PLANNING AMENDMENT

H09/1258/98

PROPOSED DWELLING
GARAGE AND
VEHICULAR ACCESS

Amendment: Reposition of dwelling and garage and reduce width
of garage (Dwg. no. 2879-2)

drawing no
2879 ~ 2

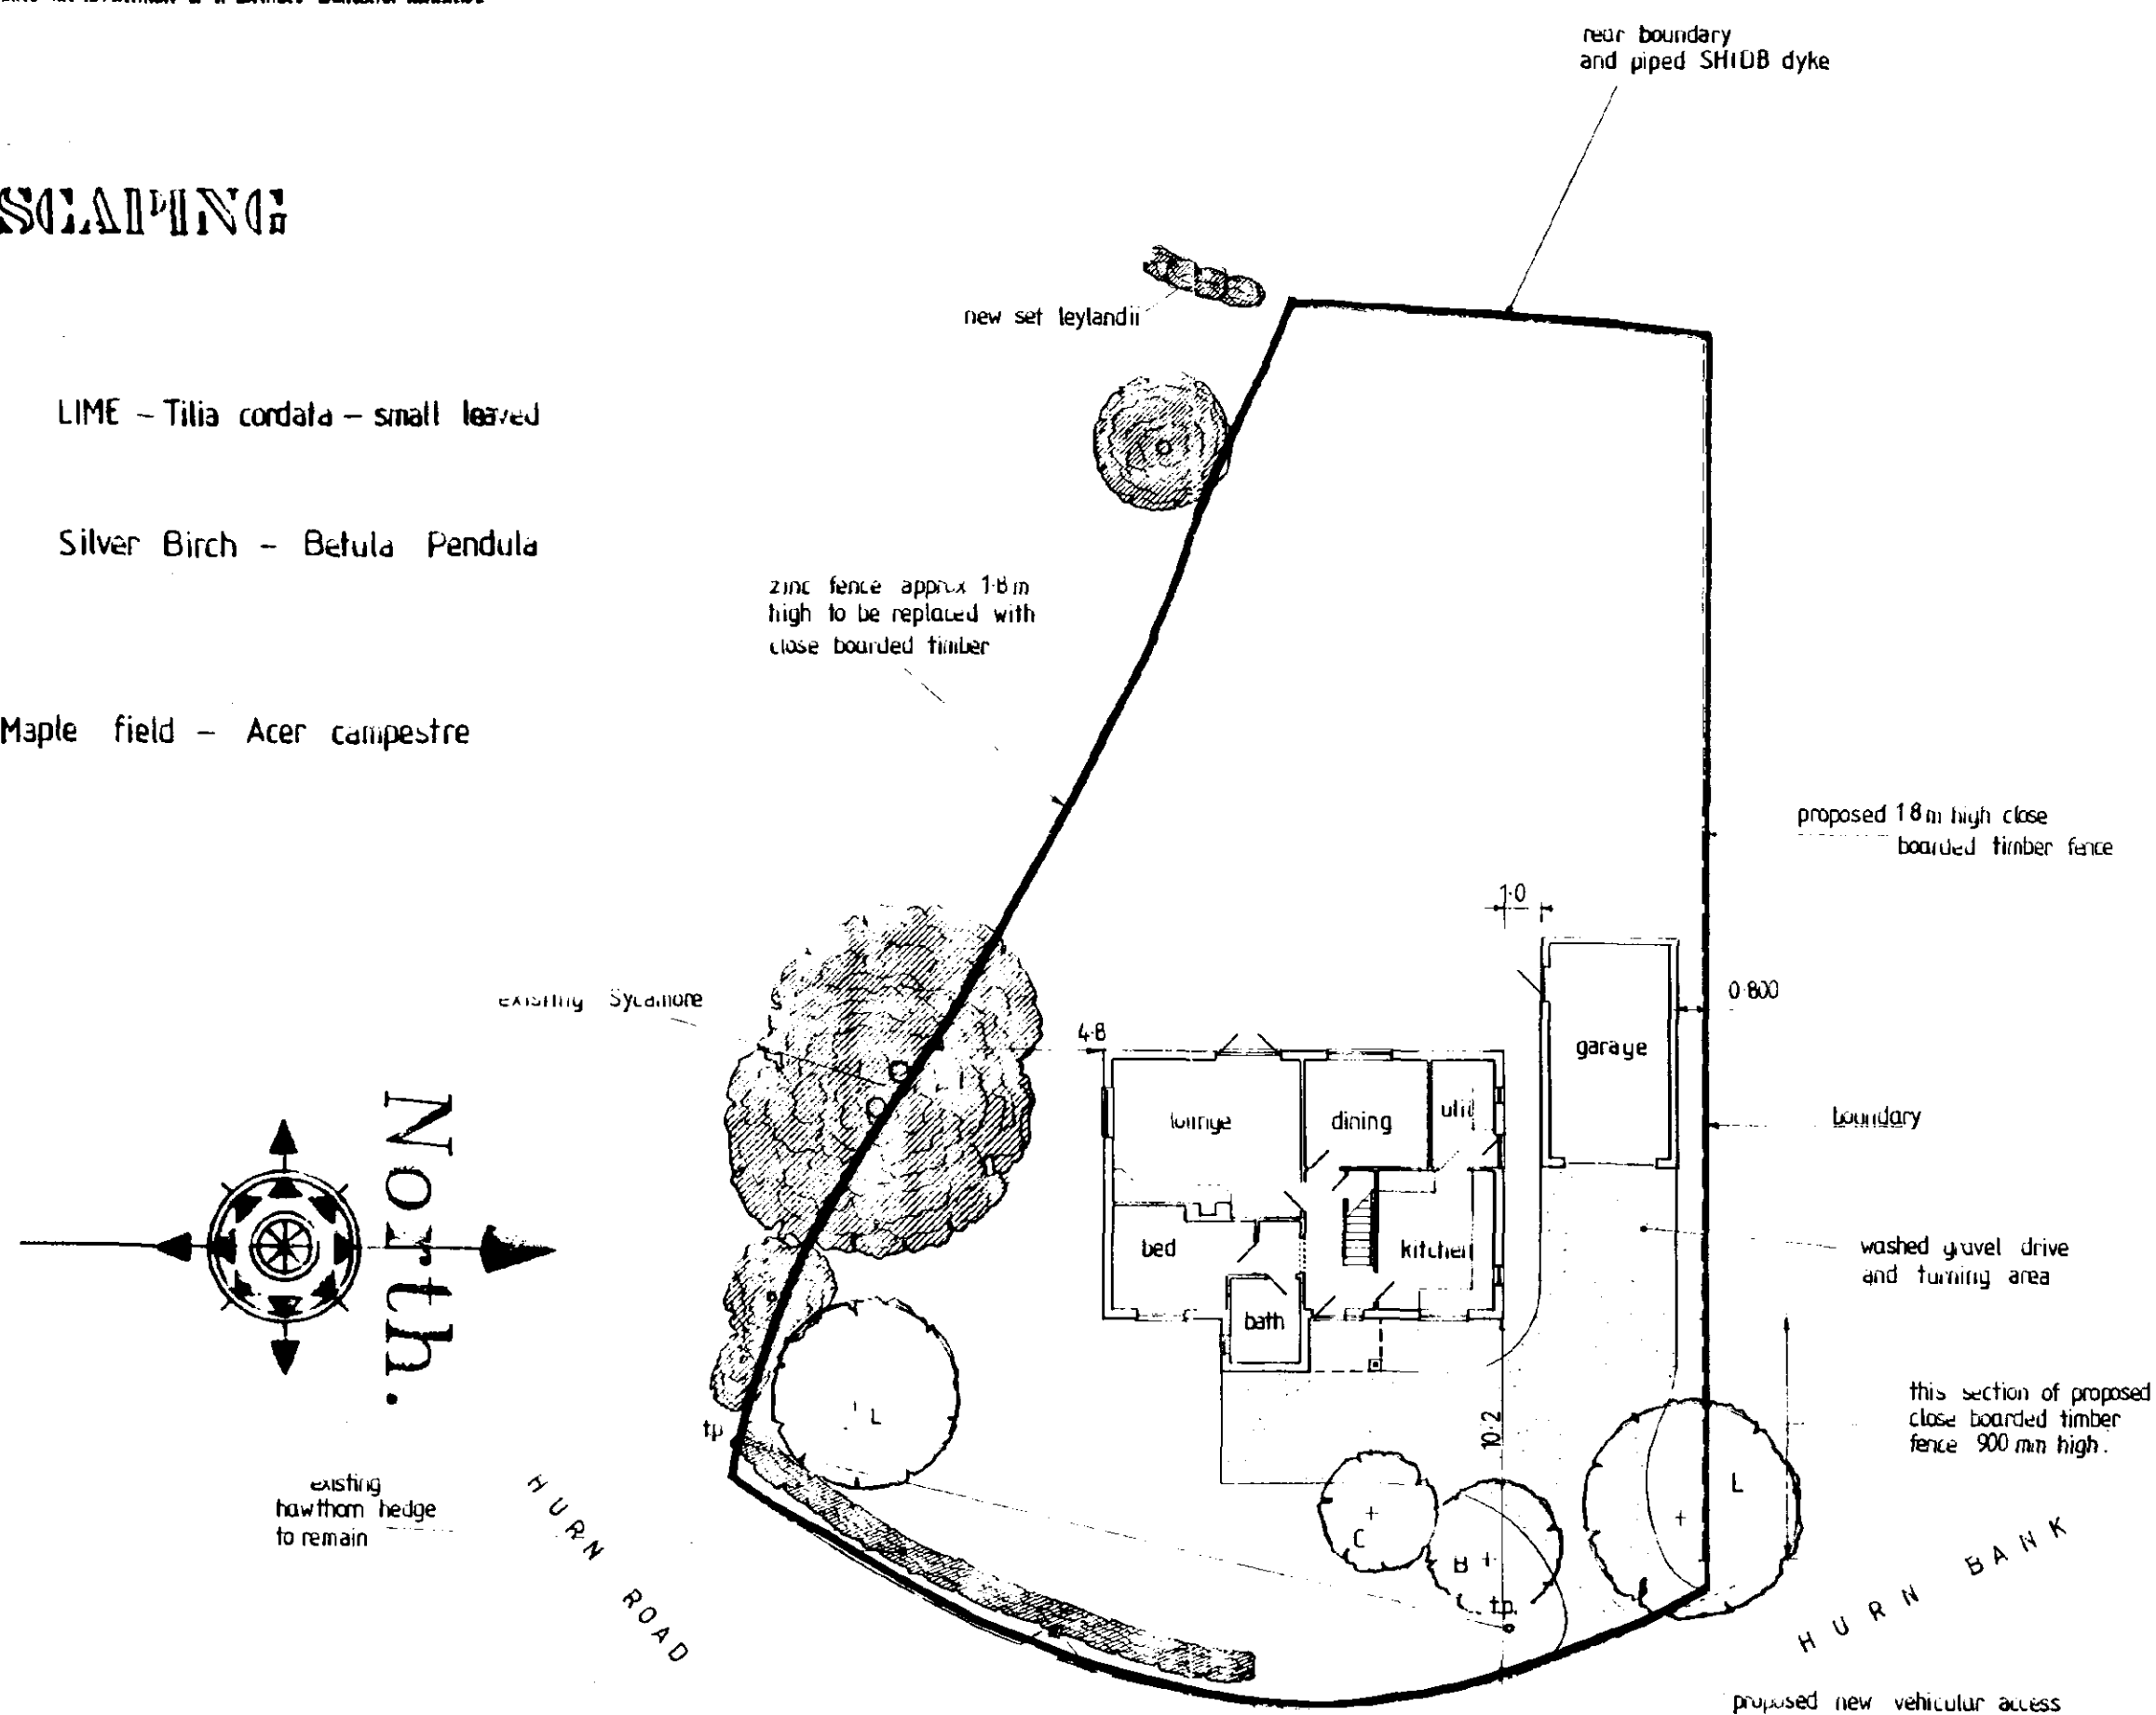
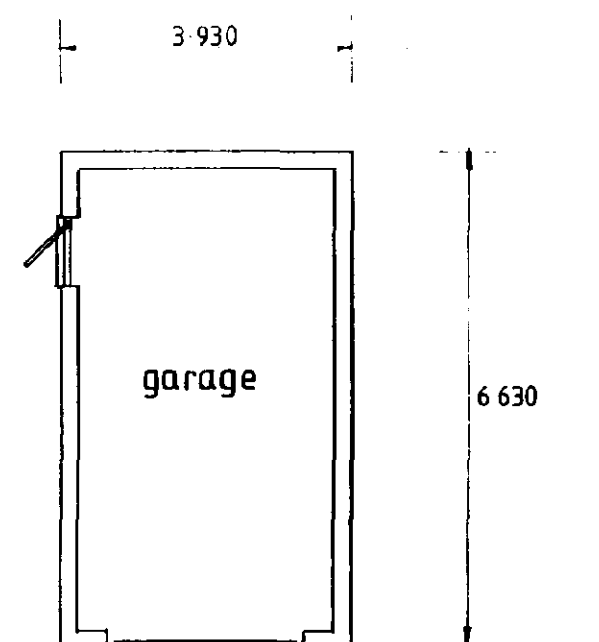
(A) REPOSITION OF DWELLING
AND GARAGE

(B) REDUCE WIDTH OF GARAGE

EXISTING HOUSE ADJACENT
PLOT SHOWN ON
1:200 SITE PLAN
